WEST SUSSEX COUNTY COUNCIL CONSULTATION

TO:	Arun District Council FAO: Hebe Smith
FROM:	WSCC – Highways Authority
DATE:	15 January 2026
LOCATION:	Land between 11A The Grove and 30 Brook Lane Ferring BN12 5HZ
SUBJECT:	FG/155/25/PL Erection of 1 No 1-bedroom self build house with associated parking & private outdoor amenity space. This application is in CIL Zone 4 and is CIL Liable as a new dwelling
DATE OF SITE VISIT:	n/a
RECOMMENDATION:	Advice

A :: 2.4 x 4.8 Car Parking
01 scale: 1:200

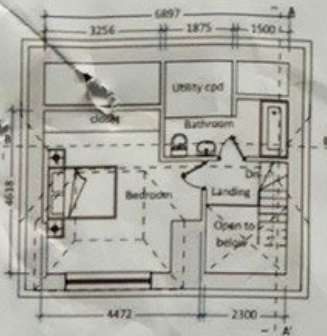
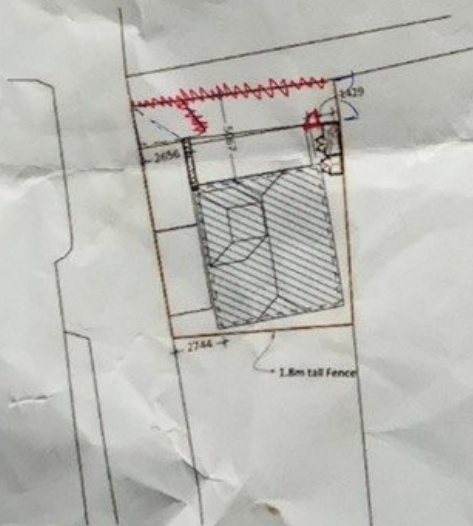
The plans demonstrate two parallel parking spaces for the proposed dwelling, which is anticipated to be sufficient for a dwelling of this size and location. Typically, a parallel parking space should be a minimum of 2.0 x 6.0m as set out in Manual for Streets, to allow manoeuvrability to and from the space. The provided spaces are 2.4 x 4.8m which may prove difficult for vehicles to manoeuvre; however, the LHA acknowledges that small vehicles could utilise these spaces. The LPA may wish to consider the amenity impacts of the proposed smaller spaces and whether this would impact upon on-street parking in this location.

No part of the development shall be first occupied until the car parking has been constructed in accordance with the approved site plan. These spaces shall thereafter be retained at all times for their designated purpose.
